RESPONSE TO SUBMISSIONS REPORT

MODIFICATION 3

BLAKEBROOK QUARRY PROJECT

January 2020

Figure 3 | An AUR intersection vs a CHR-S intersection

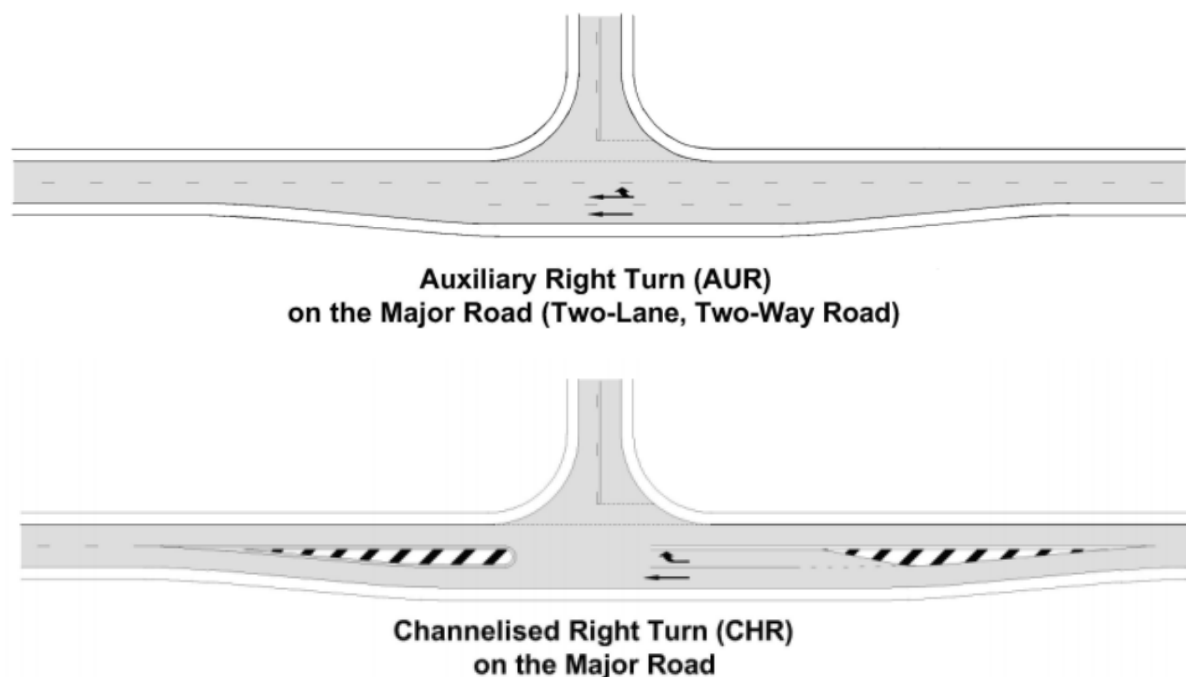
| Comments | Response |
|-----------------------------------------------------------------------------------------------------------------------------------------------------------------------------------------------------------------------------------------------------------------------------------------------------------------------|------------------------------------------------------------------------------------------------------------------------------------------------------------------------------------------------------------------------------------------------------------------------------------------------------------------------------------------------------------------------------------------------------------------------------------------------------------------------------------------------------------------------------------------------------------------------------------------------------------------------------------------------------------------------------------------------------------------------------------------------------------------------------------------------------------------------------------------------------------------------------------------------------------------------------------------------------------------------------------------------------------------------------------------------------------------------------------------------|
| <p>The Quarry Access Road and Nimbin Road intersection has a 'Type AUR Intersection Treatment' which is no longer the preferred intersection treatment recognised by Austroads. The intersection should be upgraded to provide an Austroads shortened channelised right-turn (CHR-S) treatment on the major road.</p> | <p>Page 78 of the SEE states: <i>"All intersections along the primary transport route are currently operating well within their capacity, with sufficient spare capacity to accommodate the minor increase in peak hour vehicles movements as a result of this proposal"</i>.</p> <p>Furthermore, Pages 9-10 of the Traffic Impact Assessment included as part of the application (SEE, Appendix H), states: <i>"the surrounding roads and intersections have been upgraded in recent years in order to ensure road safety can be managed. There are no changes proposed to the current transport routes. Given the minor increase in additional movements per hour, it is considered there are no further safety issues generated by the proposed modification to consent for the site operations"</i>.</p> <p>As detailed above, it is considered that the proposed increase in traffic movements does not justify any further upgrade of the intersection of the quarry's access road and Nimbin Road, which has been upgraded in accordance with Condition 21 of the existing Consent.</p> |
